BOGNOR REGIS TOWN COUNCIL

18th June 2020

**PRE-APPLICATION CONSULTATION – RADIO BASE STATION
INSTALLATION AT MBNL_ARN004 VICTORIA ROAD/CHICHESTER RD,
BOGNOR REGIS, WEST SUSSEX, PO22 9LQ. NGRs E:493470 N:99960**

Title:
265 MAX CONFIGURATION ELEVATION

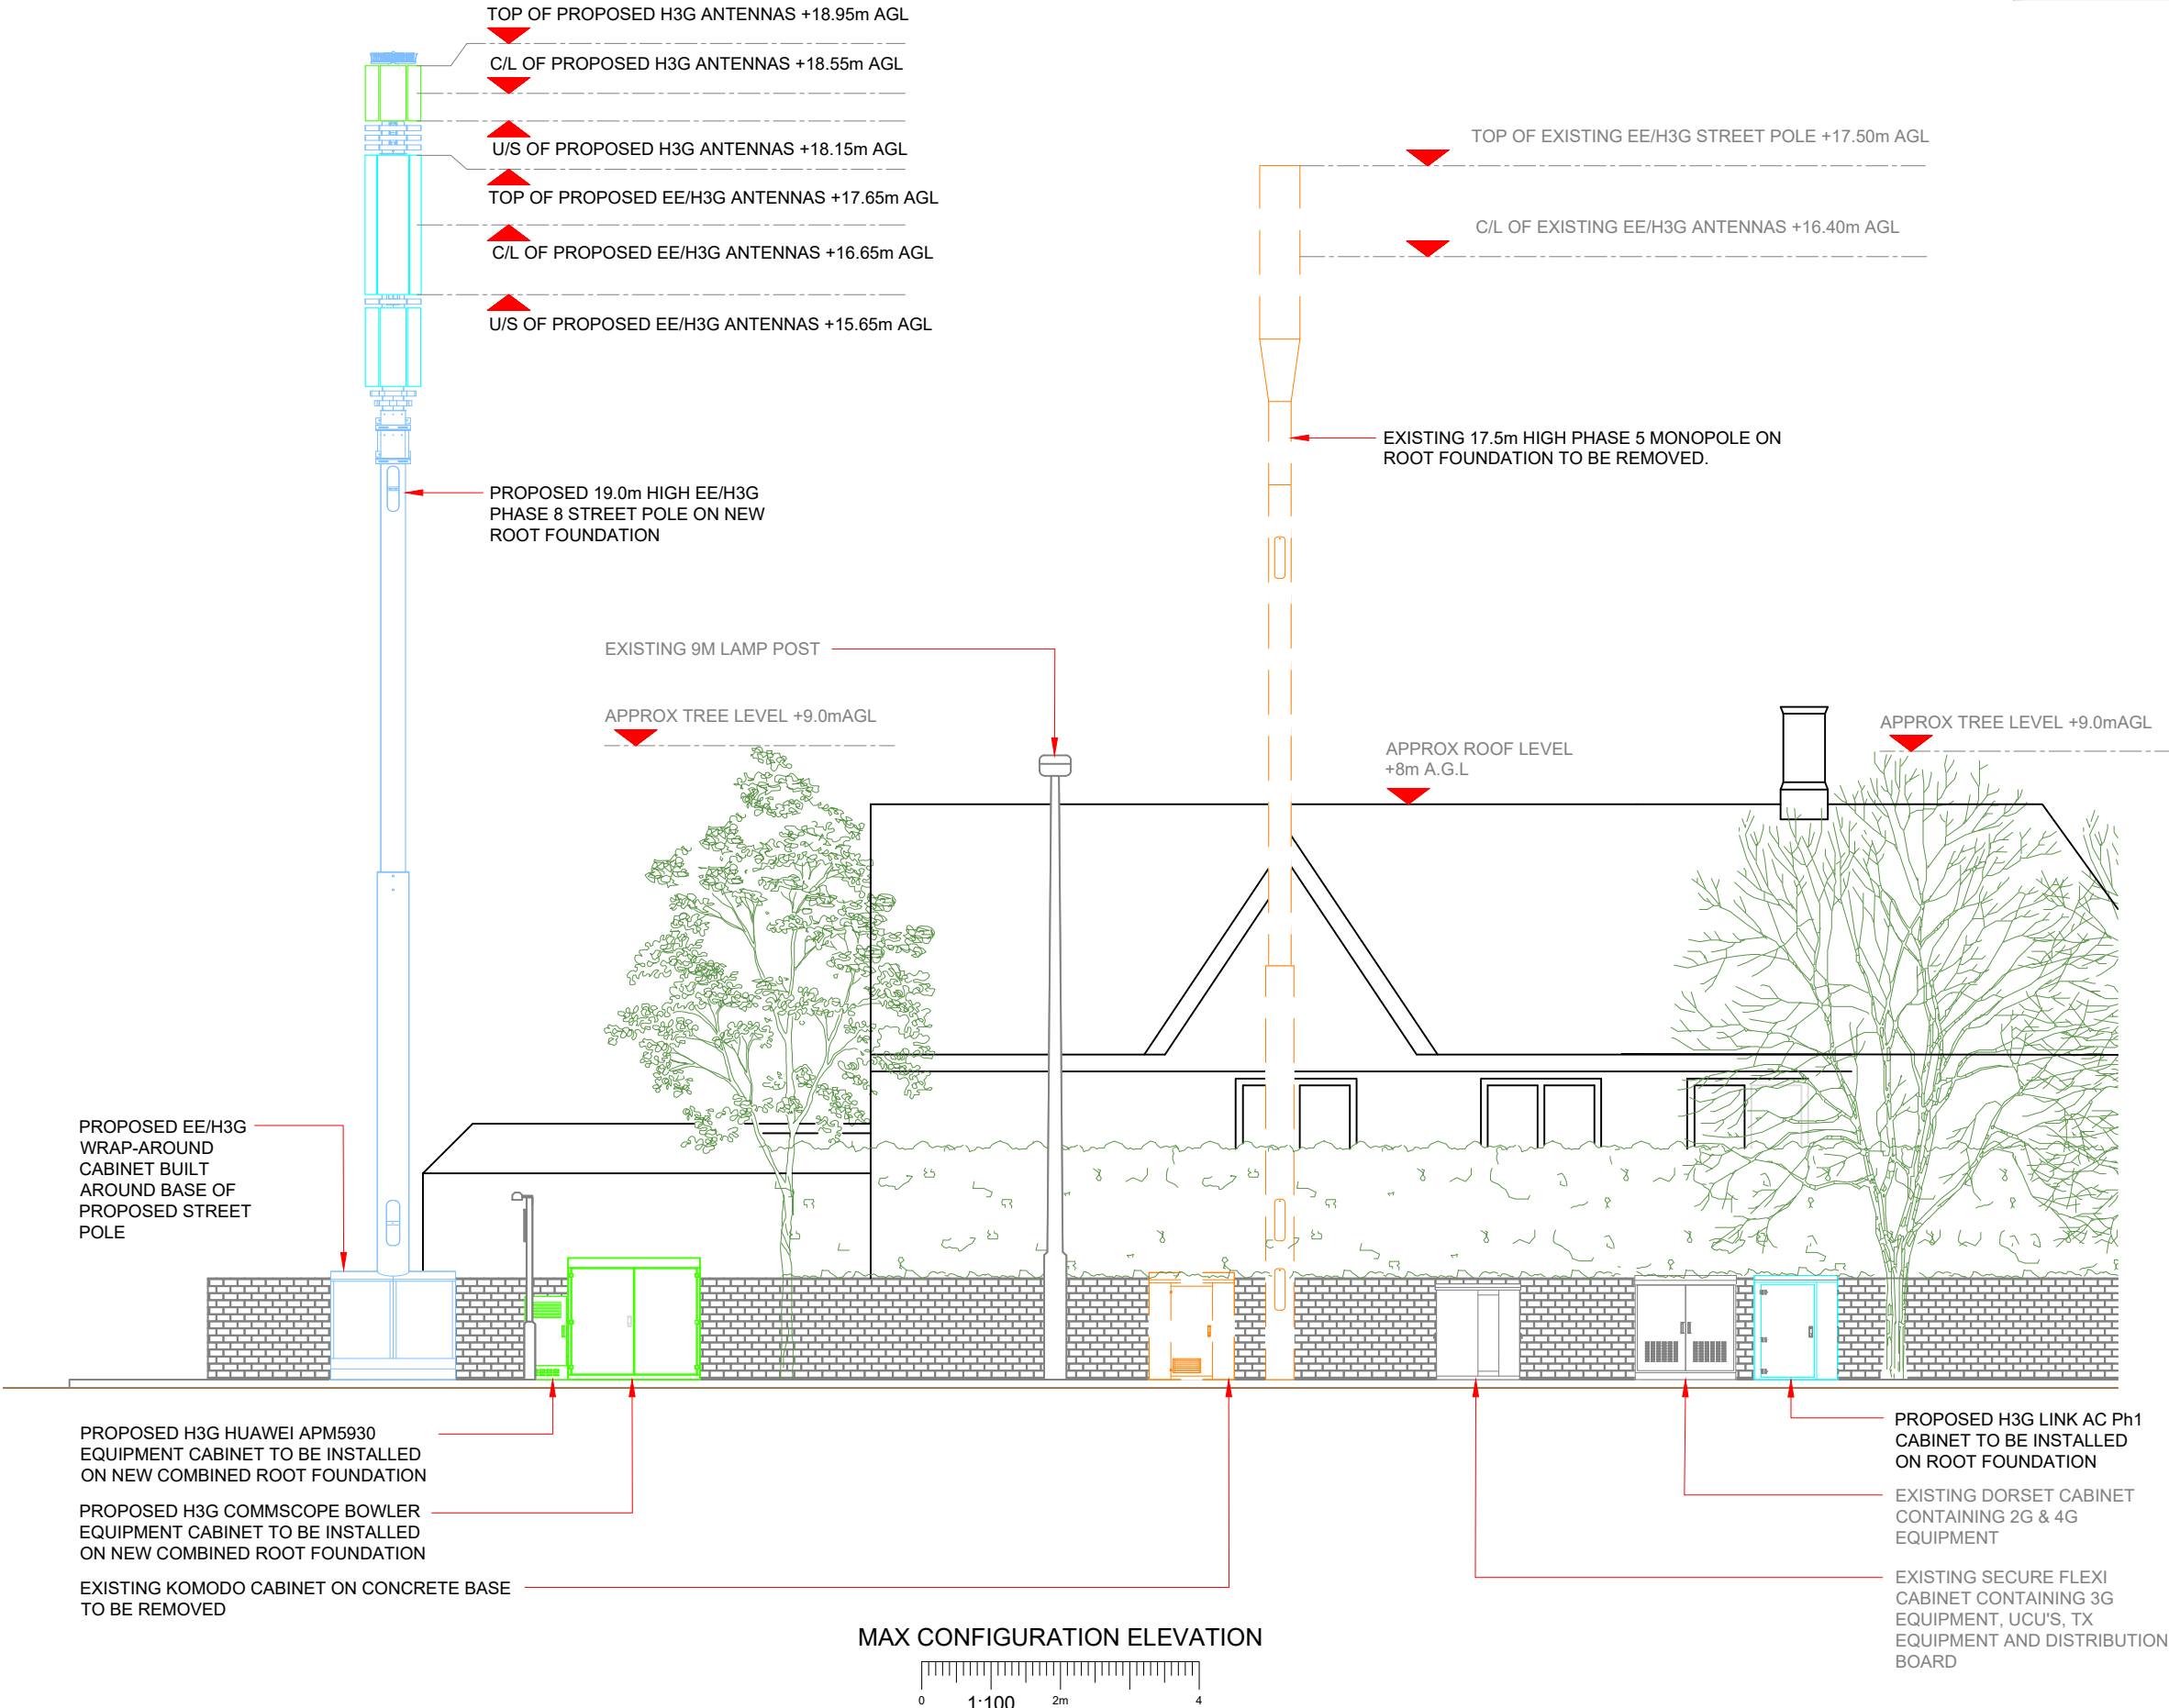
Additionally, Members discussed the potentially negative impact of the proposed installation, due to its size and appearance, to residents living within the immediate vicinity. Although it's acknowledged that this planned upgrade is on a site at which equipment is presently located, is it at all possible that an alternative site, that would lessen the impact on local residents, could be considered?
